[REDACTED]
Infrastructure Manager
Lincolnshire County Council
County Offices
Newland
Lincoln LN1 1YL

Date: 16 July 2026

Application by Beacon Fen Energy Park Limited for an Order granting Development Consent for the Beacon Fen Energy Park Project

DO NOT SCALE FROM THIS DRAWING

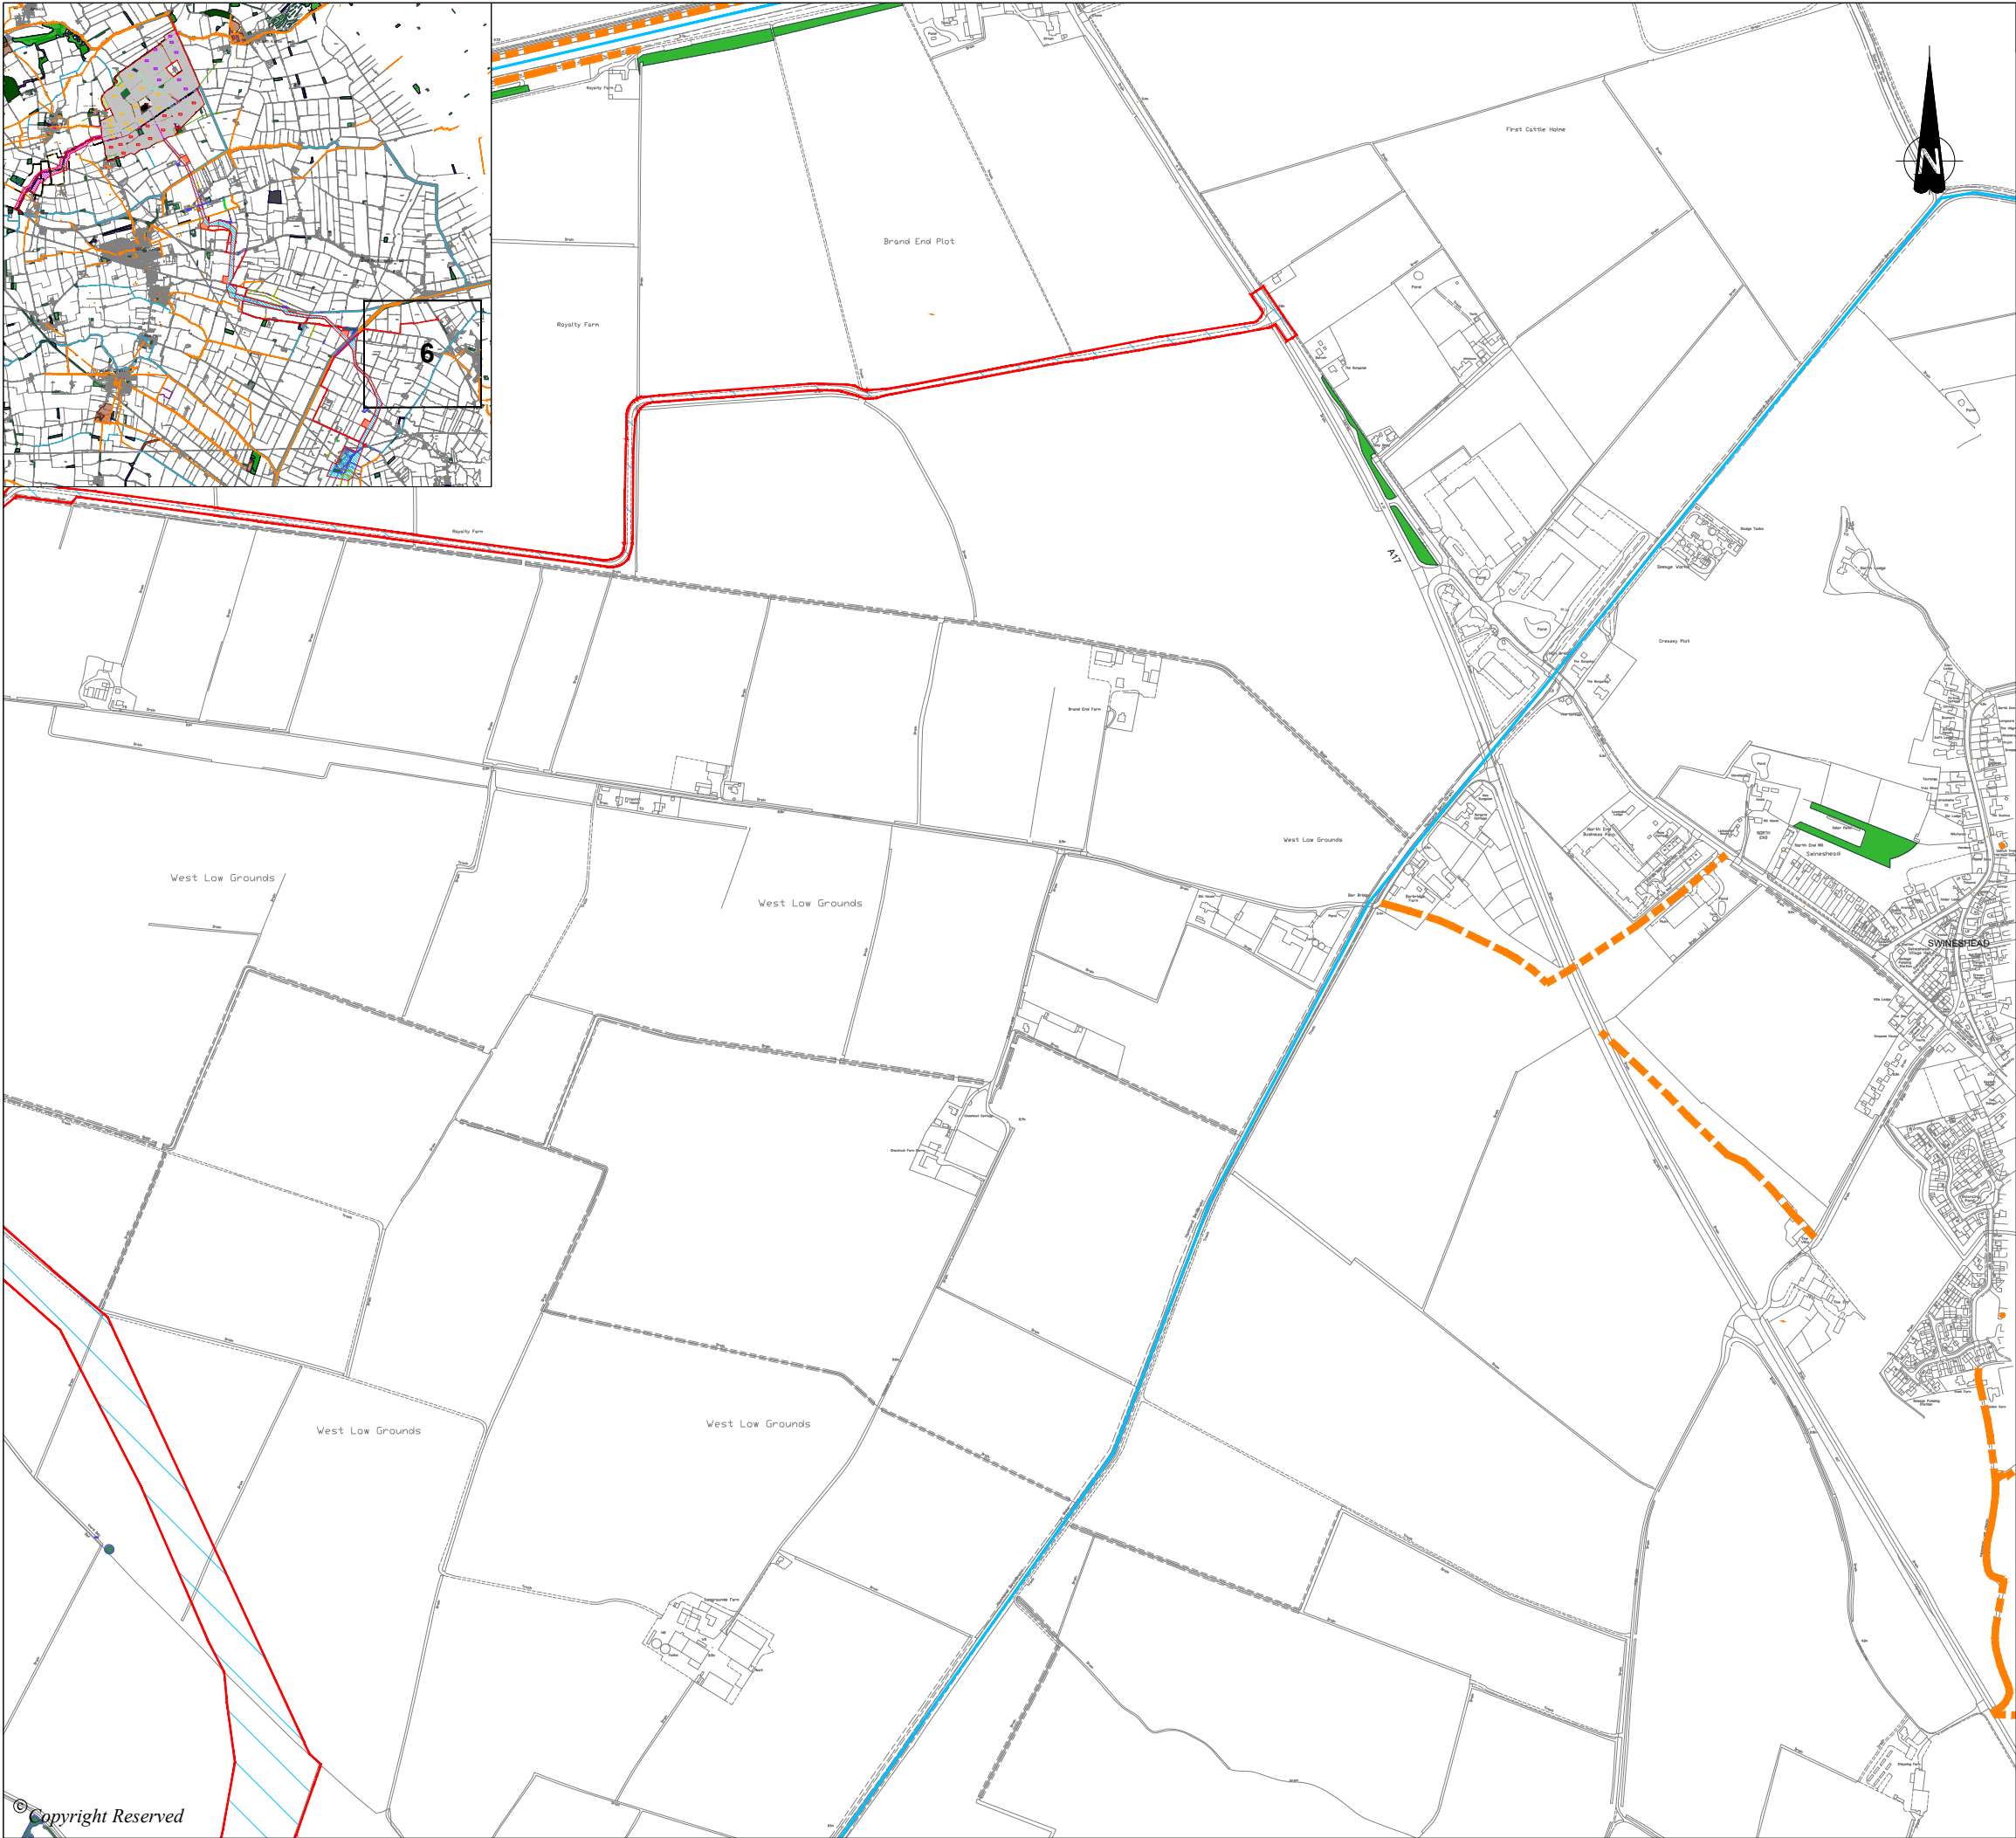
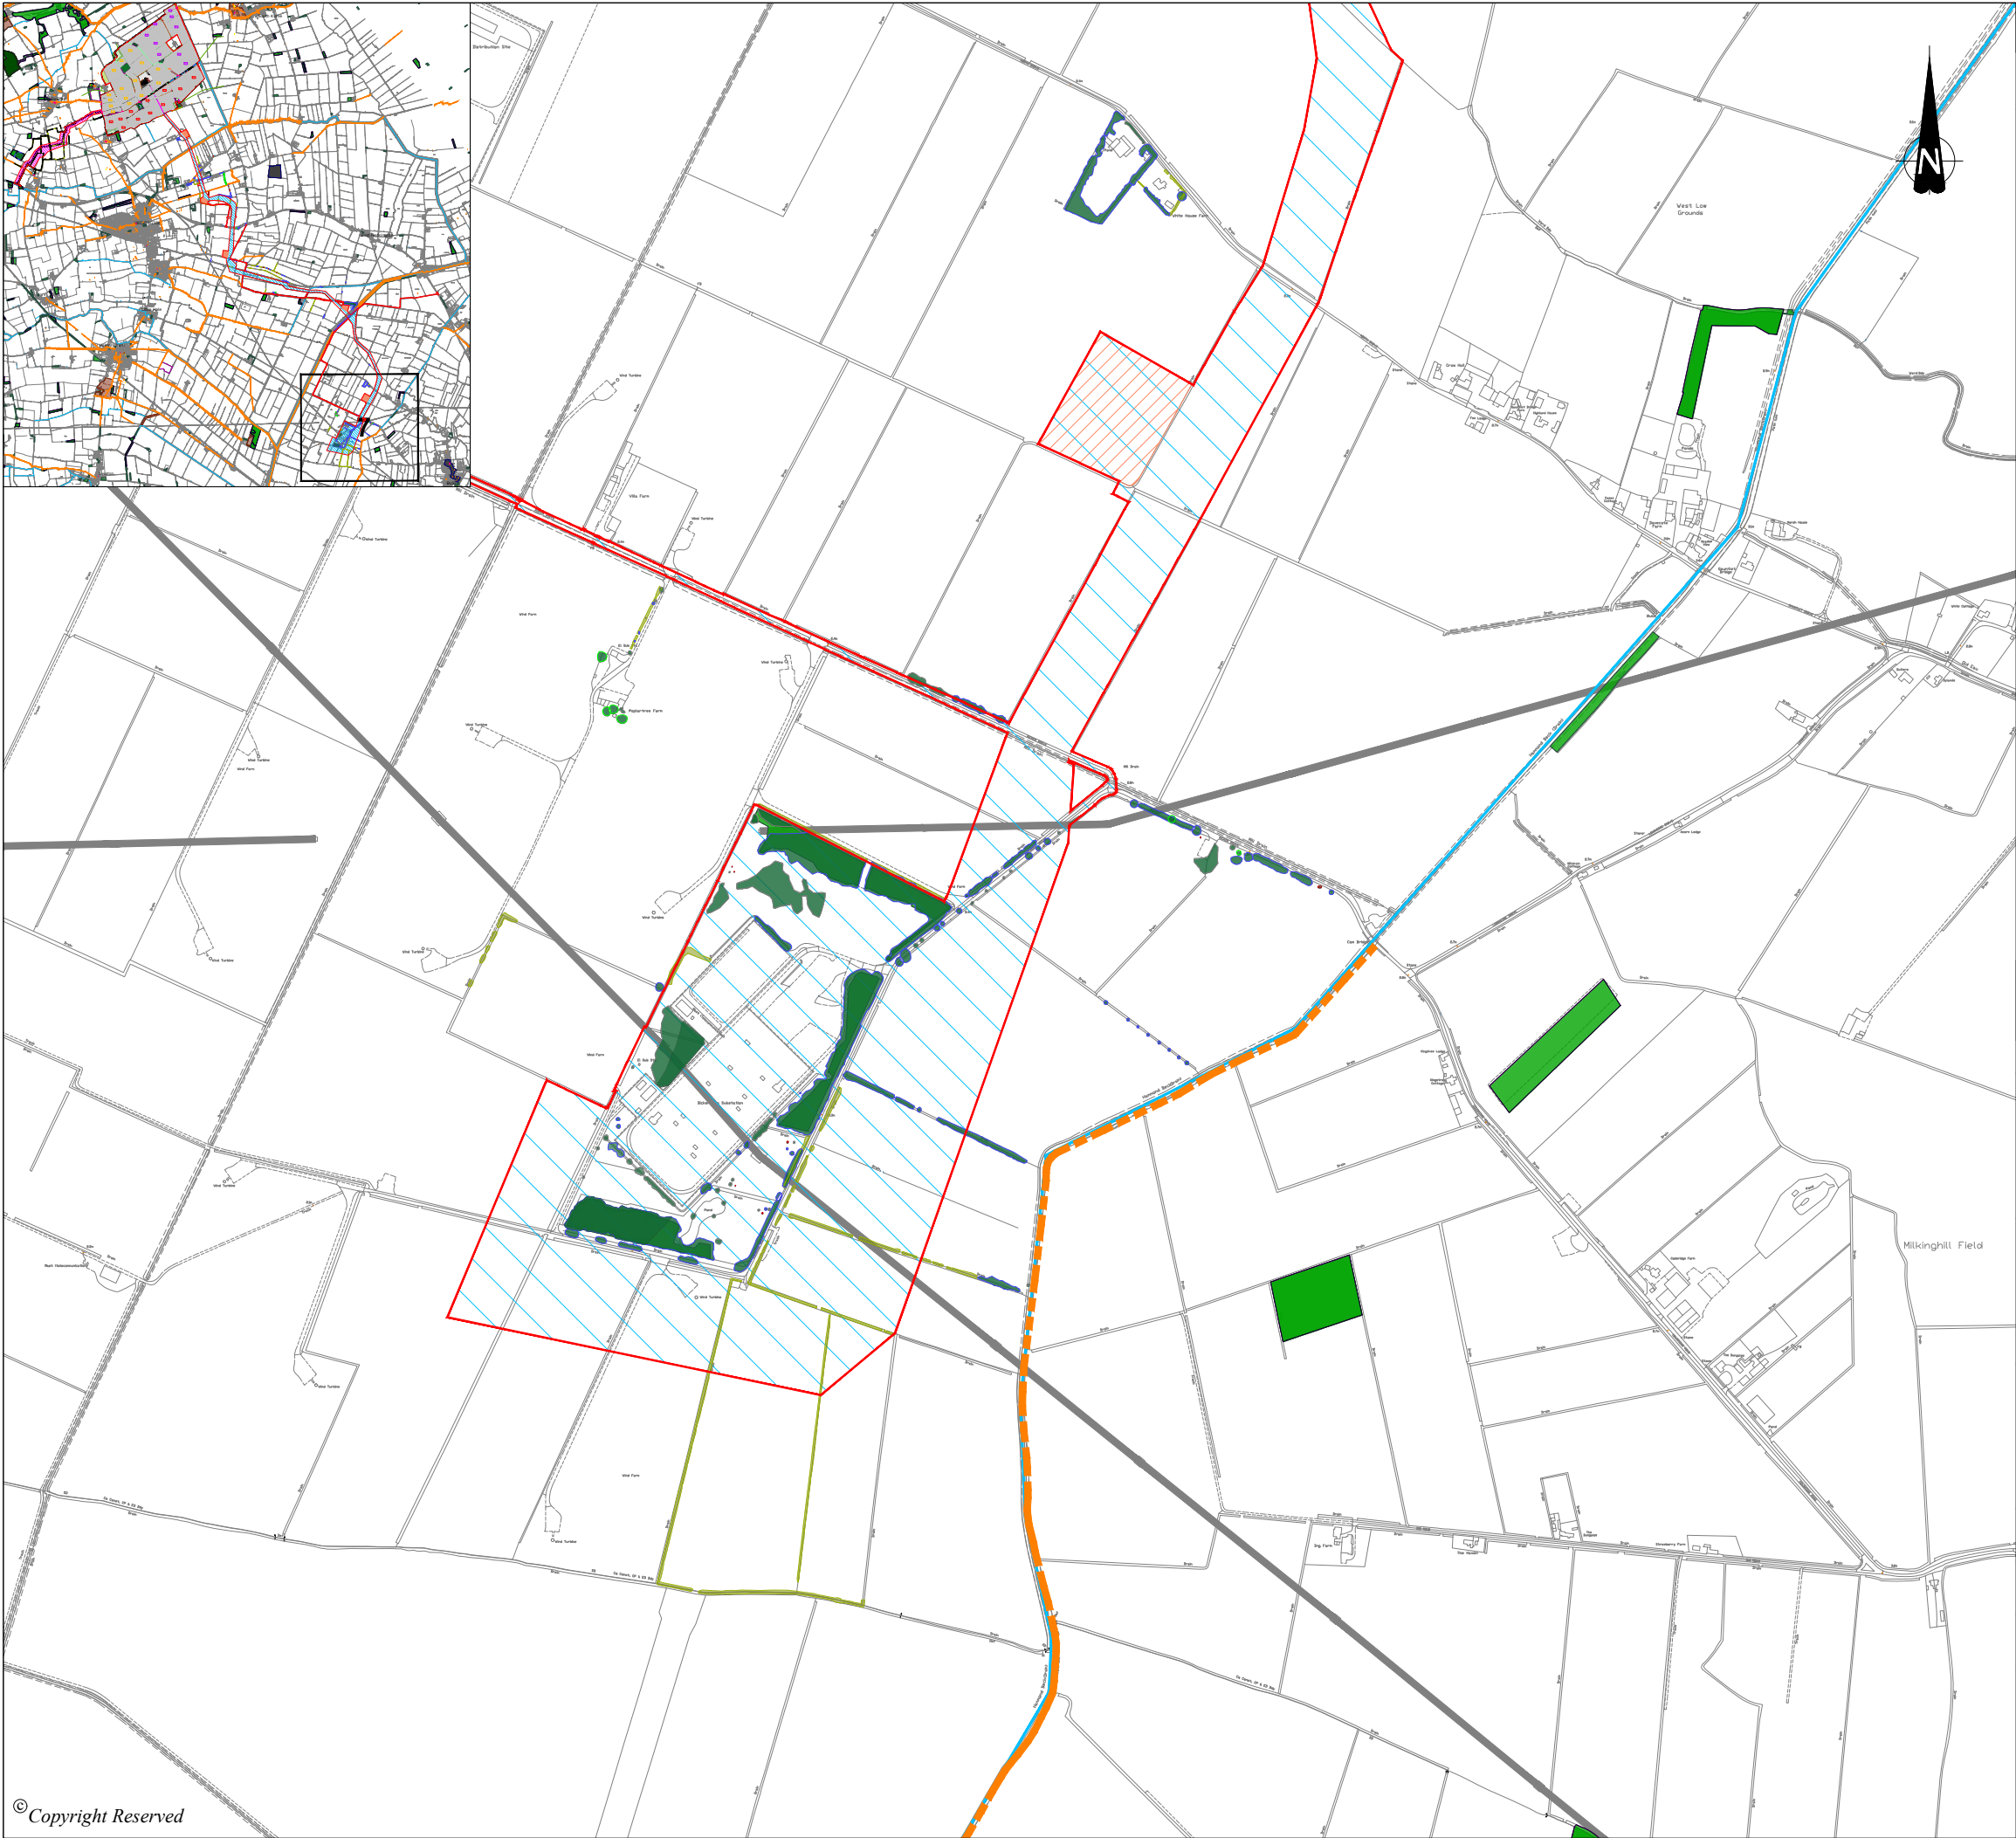
The Council notes the Applicant's responses to questions on mitigation for skylark and bats. In relation to mitigation provided for skylark, the Applicant has stated that PV exclusion zones areas identified in 6.4.4 Figure 1.4 Indicative Site Layout Plan (Revision 1) [REP2-028] *"...will be managed to support a greater density of skylark than at present..."*. The Council also notes the Applicant's updates to the Outline Landscape and Ecological Management Plan which state that *"Within the open buffer areas adjacent to ditches and in the wildflower meadows the habitats will be improved for ground nesting birds, including skylark,..."*. Whilst the Council welcomes these commitments and recognises the potential value of these areas for foraging birds, the exclusion zones identified in REP2-028 and buffer areas adjacent to ditches are considered unlikely to be of sufficient scale or openness to accommodate skylark's ecological requirements for extensive open habitat and unobstructed sightlines in order to successfully nest. The latest research strongly suggests that skylark actively avoid panel arrays for breeding purposes, along with any boundary feature >3m, using these grassland areas instead for foraging. The extent of this avoidance behaviour is 50-85m from boundary features >3m meaning the vast majority of the development site will become unsuitable for breeding skylark."

With the above in mind, the Council maintains its position stated during the examination that there is insufficient mitigation provision for ground nesting farmland birds, in particular skylark. ES Chapter 7 Ecology (Revision 4)[REP8-013] predicts a “permanent very low adverse impact” on skylark (REP8-013, 7.6.61). The Council therefore remains concerned about the potential for cumulative impacts on ground nesting bird species, particularly skylark, arising from the number of similar developments across the County.
